Objection Submission to An Coimisiún Pleanála

Re: Planning permission for the construction of Tirawley Windfarm consisting of 16 no. wind turbines, a permanent 110kV substation, an energy storage system in the form of a battery array located within container units, 110kV underground cable and grid connection, and ancillary development in the townlands of Ballymurphy, Ballynaleck, Barnhill Lower & Upper, Barroe, Billoos, Carn, Carrickanass, Carrowmore, Castlelacken Demesne, and other townlands in County Mayo.

Case Number: PAX16.324258

| 6289 | PL-2001 | 0 |

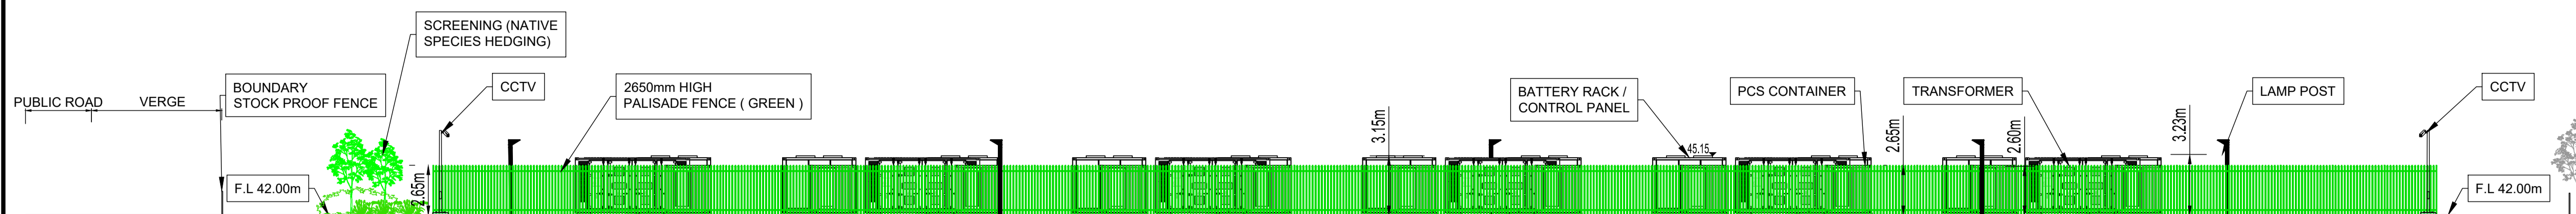
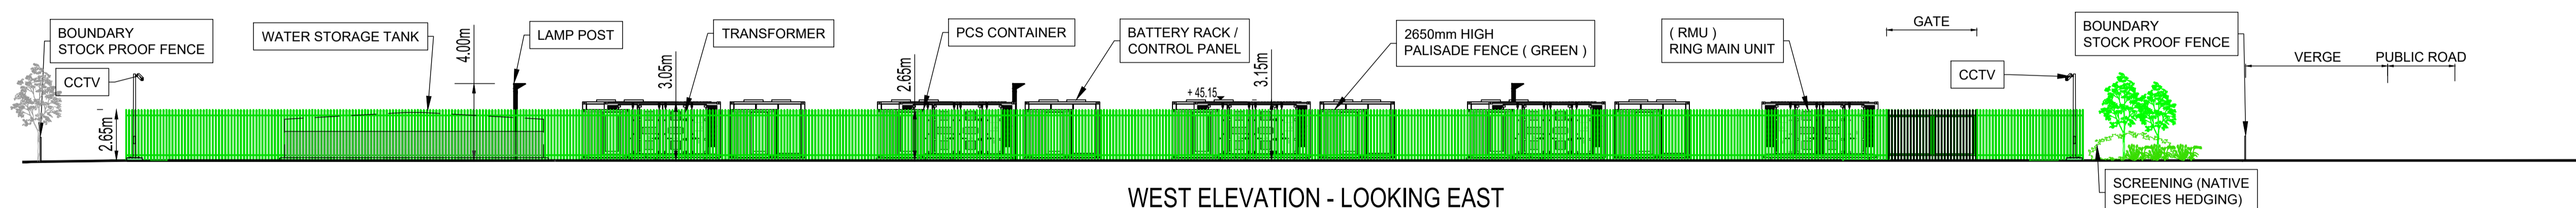
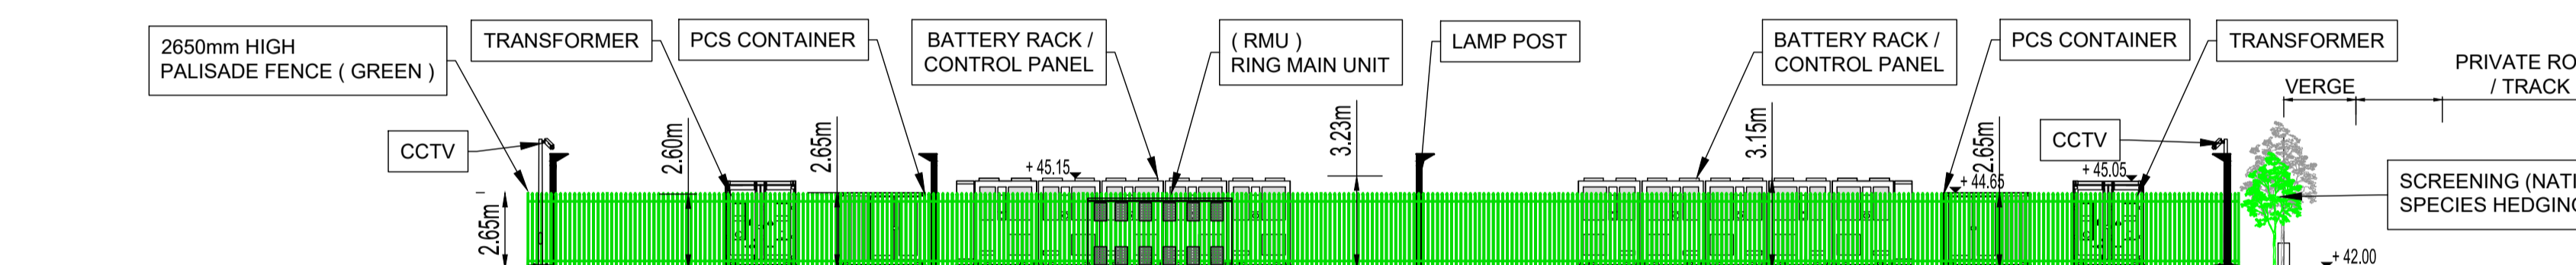
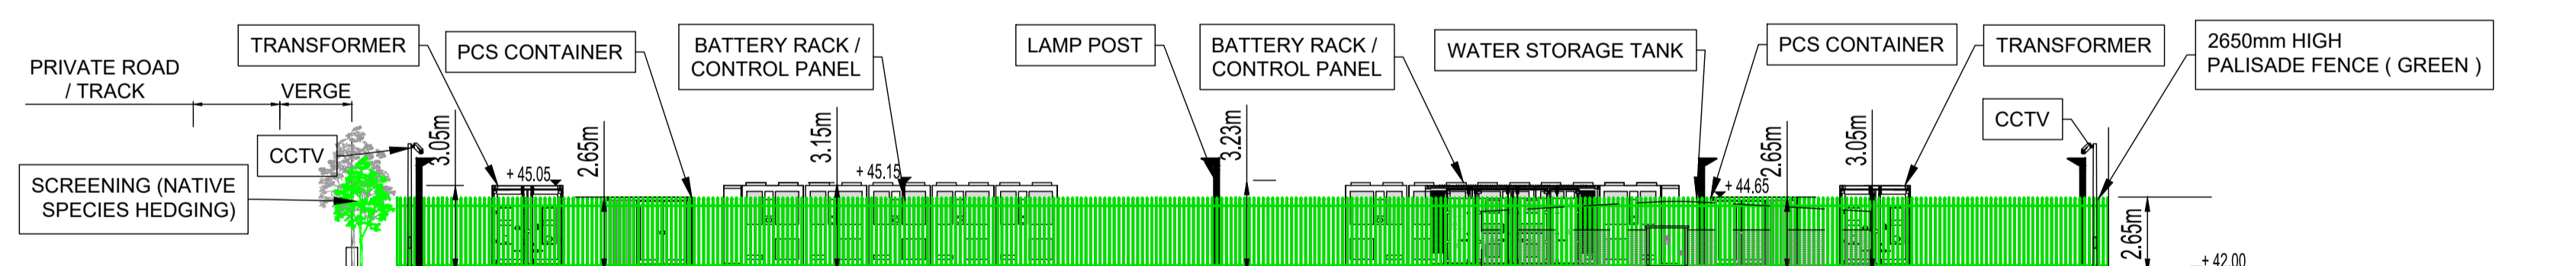
My grazing land lies adjacent (approximately 5m across the road) to and downslope of the proposed BESS location. The natural topography of the site means that any uncontained firewater will flow directly towards my land in Carrickanass. If this contaminated water reaches my grazing land, the grass consumed daily by my cattle will be contaminated with heavy metals and toxic chemicals.

- Total fire-water containment capacity (bunding) sufficient to retain 110% of maximum fire-suppression water volume.
- Zero discharge capability to any surface water or adjacent agricultural land
- A contaminated water removal and disposal protocol.
- Any assessment of the impact of fire-water run-off on adjacent agricultural enterprises

In the absence of such demonstration, the BESS must be relocated to a position where topography and engineered containment prevent any possibility of run-off reaching my productive farmland.

Figure 4.4 – Proposed Site Overlay on Map 8 of the Mayo RES

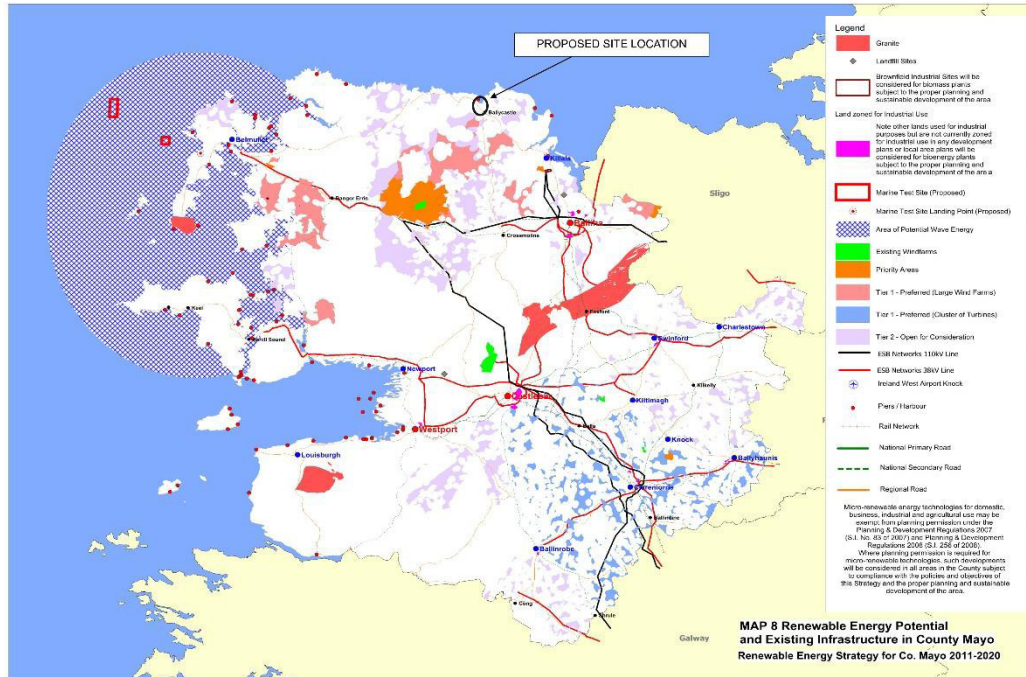
I submit that the proposed BESS is located outside the area designated as "Open to Consideration" for wind energy development in the Mayo County Development Plan 2022–2028 (incorporating the Renewable Energy Strategy for County Mayo 2011–2022). It is also important to note that the proposed site location is incorrectly marked on Figure 4.2 - Proposed Site Overlain on Map 8 of the Mayo RES, refer to attached Appendix 1.
